NSIP: National Significant Infrastructure Project (DCO)
Oaklands Farm Solar Park, Coton Road, Walton-on-Trent, Derbyshire
[Case Ref. PL00755482; HE File Ref. .; Your Reference. EN010122-000013]

Our ref: PL00755482

3 May 2024

Oaklands Farm Solar Park: Solar photovoltaic array and electrical storage and connection infrastructure, with a generation capacity of greater than 50 MW.

Figure 7.1: Heritage Assets Identified as Potentially Susceptible to Effects

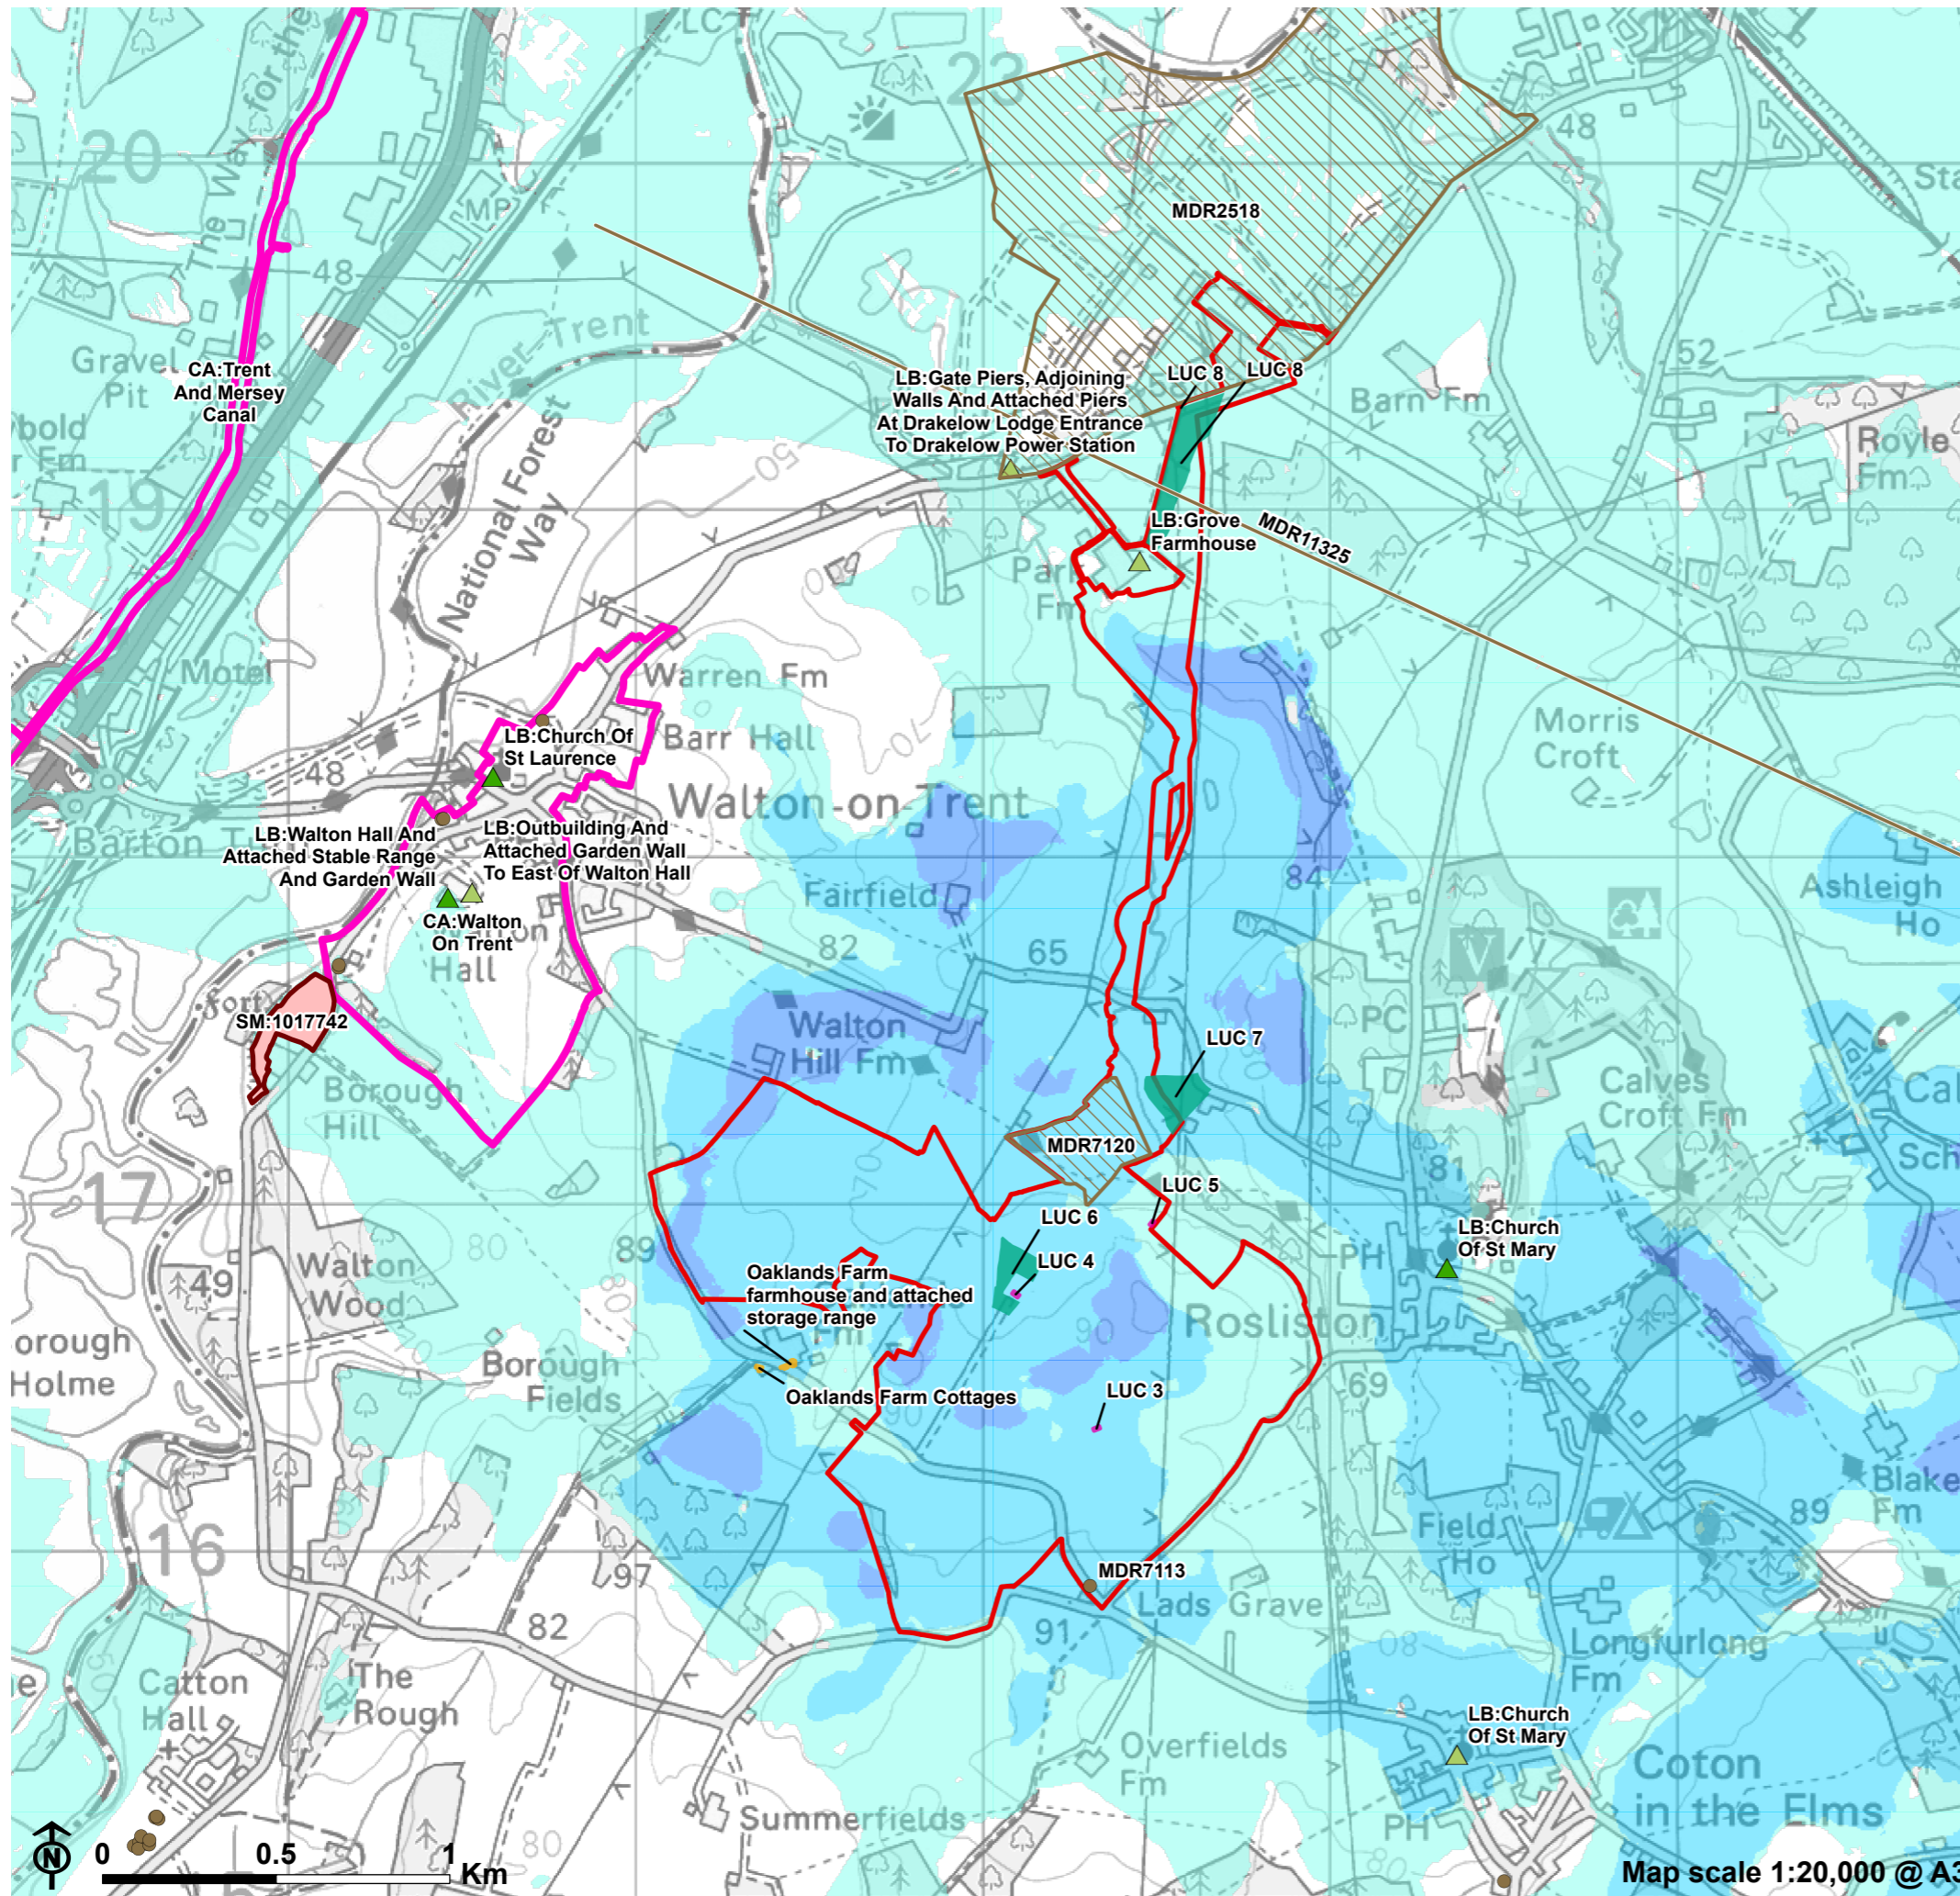
The proposal causes harm to the setting and visual interconnectivity of multiple heritage assets. This includes the Scheduled Monument Hillfort southwest of Old Hall Cottages, to the southwest of the development site, and several Grade II* listed buildings, the Church of St Laurence and Walton Hall at Walton-on-Trent, Church of St Giles and Caldwell Hall, Caldwell, Church of St Mary at Rosliston, and Catton Hall at Coton in the Elms.

The development site also harms the setting of multiple Grade II listed buildings within the villages of Walton-on-Trent, also a conservation area, Caldwell, Rosliston, and Coton in the Elms. These buildings form the foundation of these settlements and a testament to the rural heritage of these communities. The buildings to the North also form part of the remains of the Drakelow Hall estate where the house has been lost

The layout in its current form, as of October 2023, proposes the PV arrays to the south of the site where it will impact upon these heritage assets. The proposal will require suitable landscape mitigation, which has not been adequately demonstrated, to resolve the impact on the setting of these heritage assets and the interconnectivity between them and the site. The development to the north, depending on final details, will have less impact on the setting of the heritage assets. The concerns raised here regarding the location, views and the need for mitigation need further, close consideration in any revised documents and plans. As part of this reducing the proximity to the settlement of Walton-on-Trent and the Scheduled Monument along the west boundary should be considered to mitigate the harm mentioned above.
